From: Amanda Scholes on behalf of Planning.Responses
Sent: 17 October 2019 08:53
To: Planning Scanning
Subject: FW: A/113/19/DOC - Crete Nursery Condition 4

I have just formally consulted you on Condition 4 below to which the applicants have provided the attached lighting plan.

Prior to occupation of the dwellings details of any external lighting for the site shall be submitted to and approved by the Local Planning Authority and should take into consideration the presence of bats in the local area and the scheme should minimise potential impacts to any bats using the trees, hedgerows and buildings by avoiding unnecessary artificial light spill through the use of directional light sources and shielding. The development shall proceed in accordance with the approved details and any further external lighting shall be subject to the prior permission of the Local Planning Authority.

Road Markings, Signs & Lighting

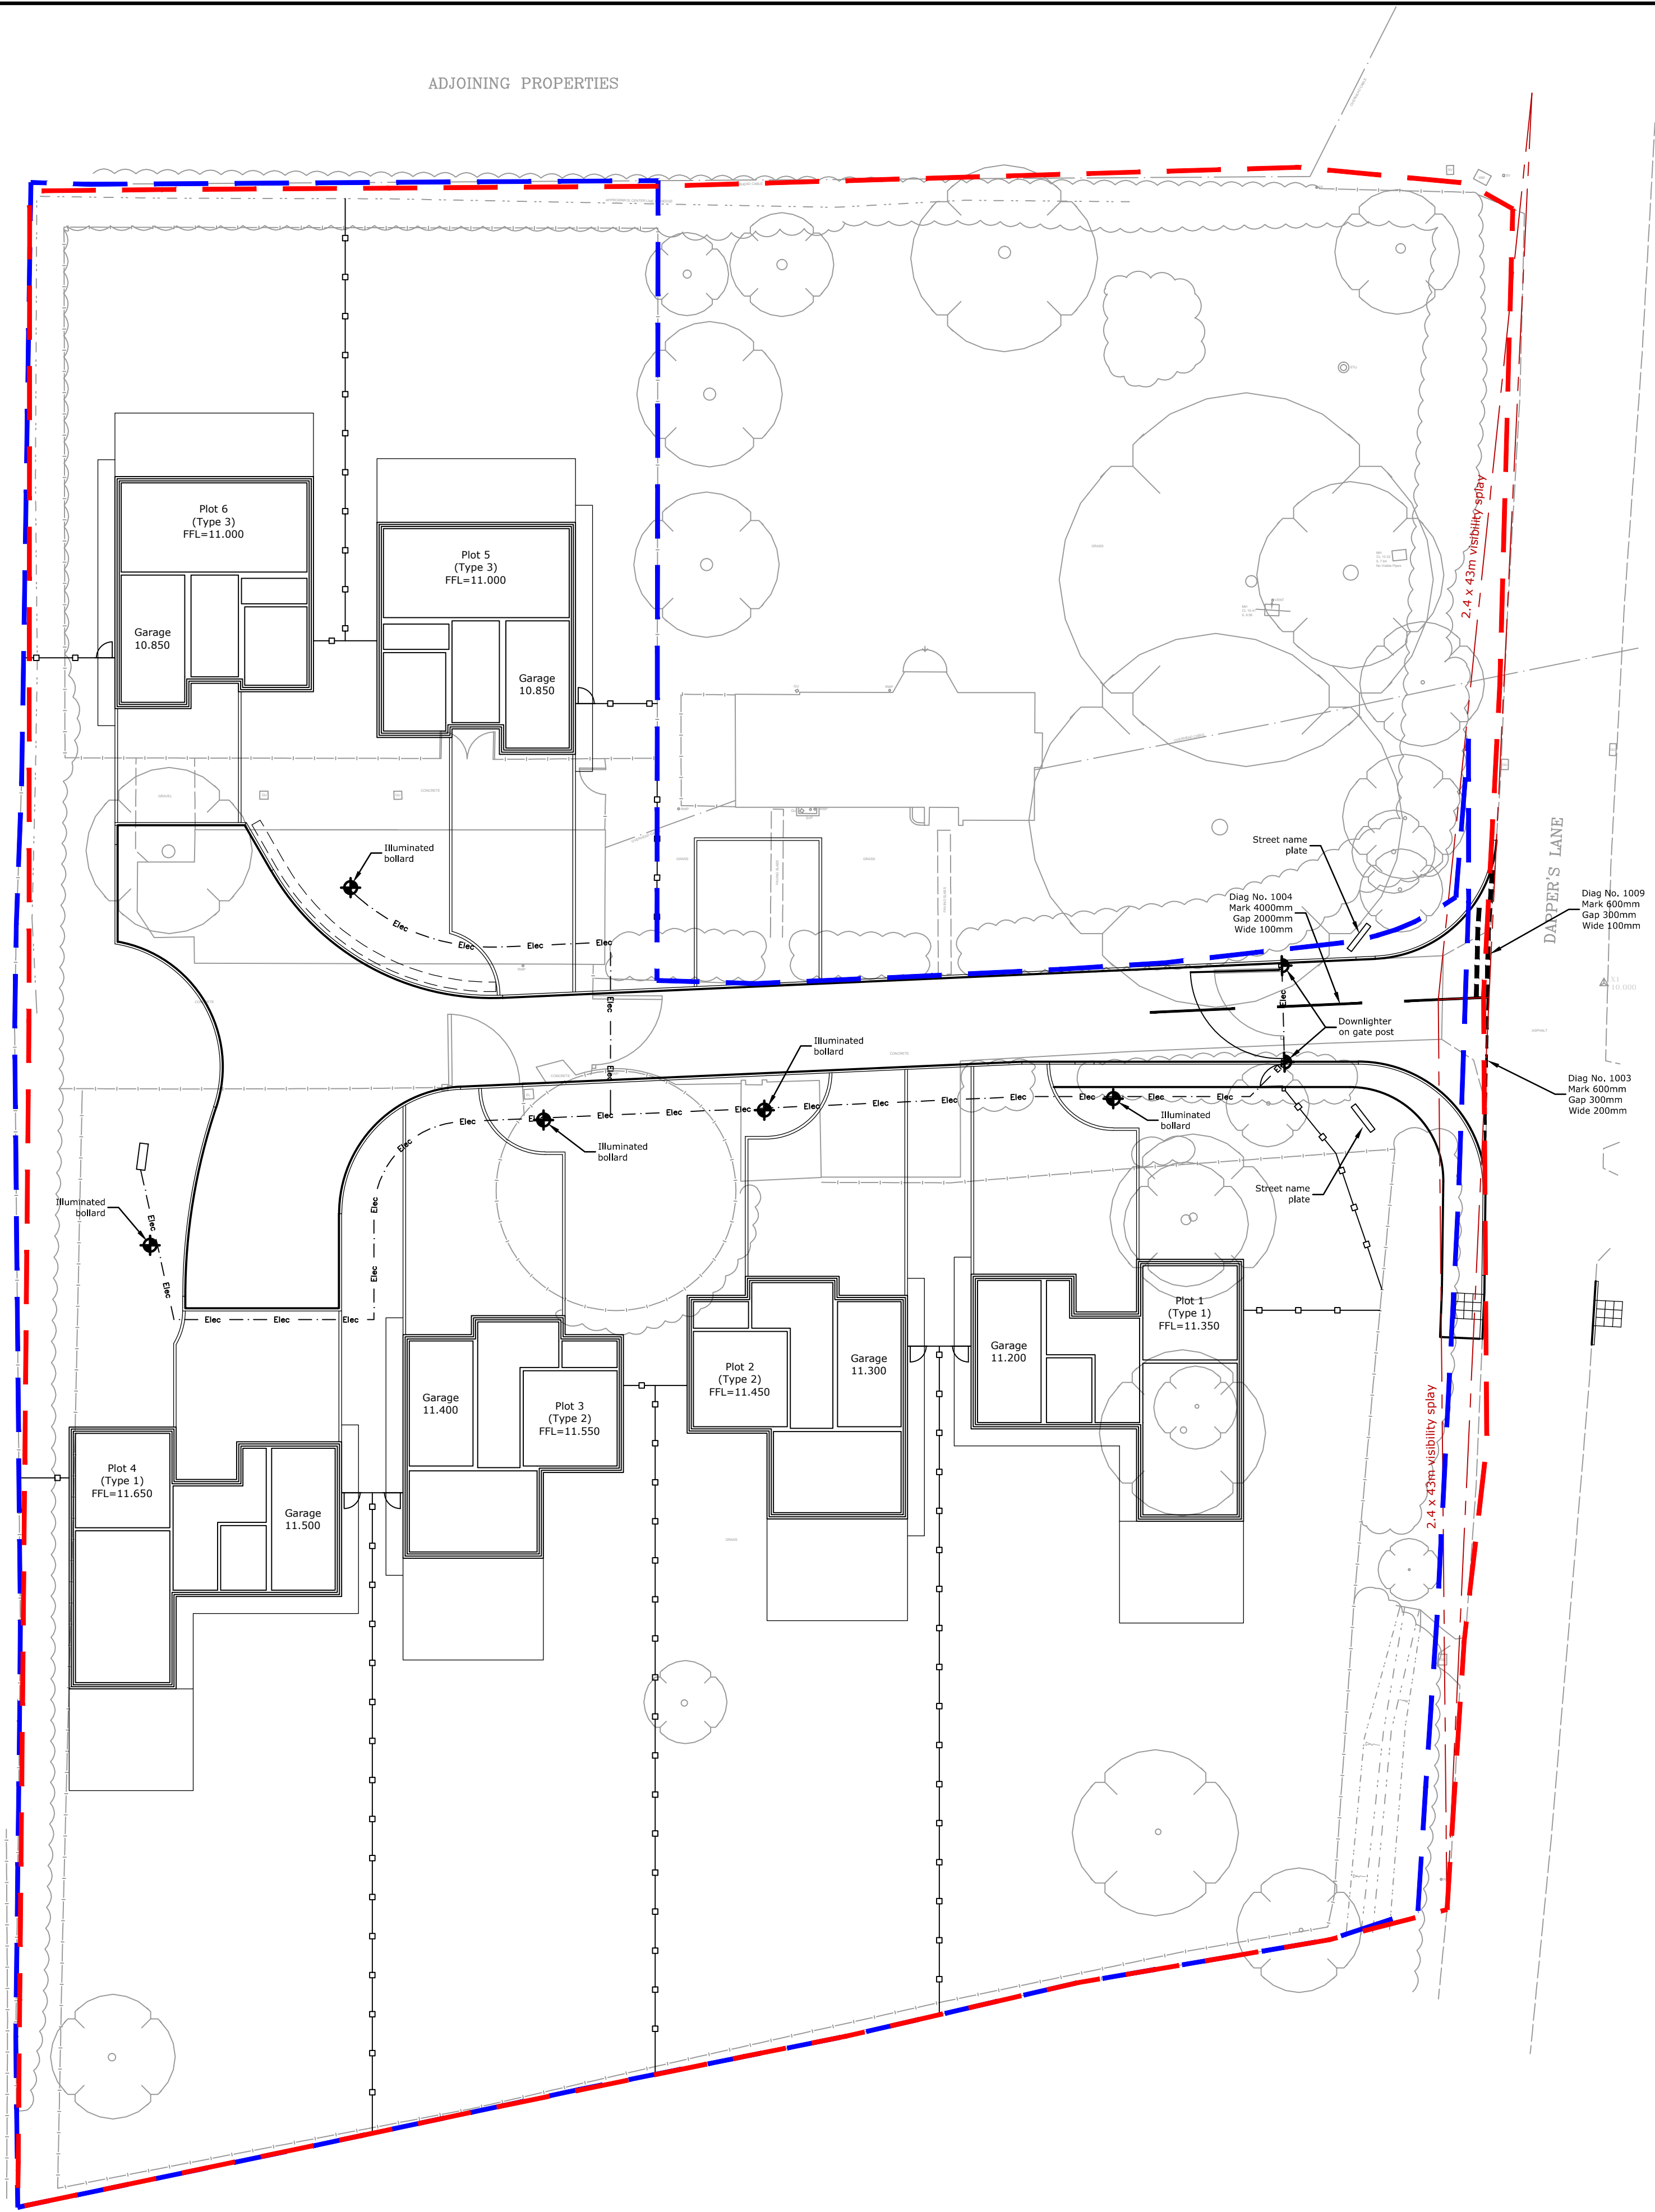
Looking at the plan I am happy with the bollard lighting, however can I confirm, is there going to be any external lighting on the houses as this will need to be considered too.
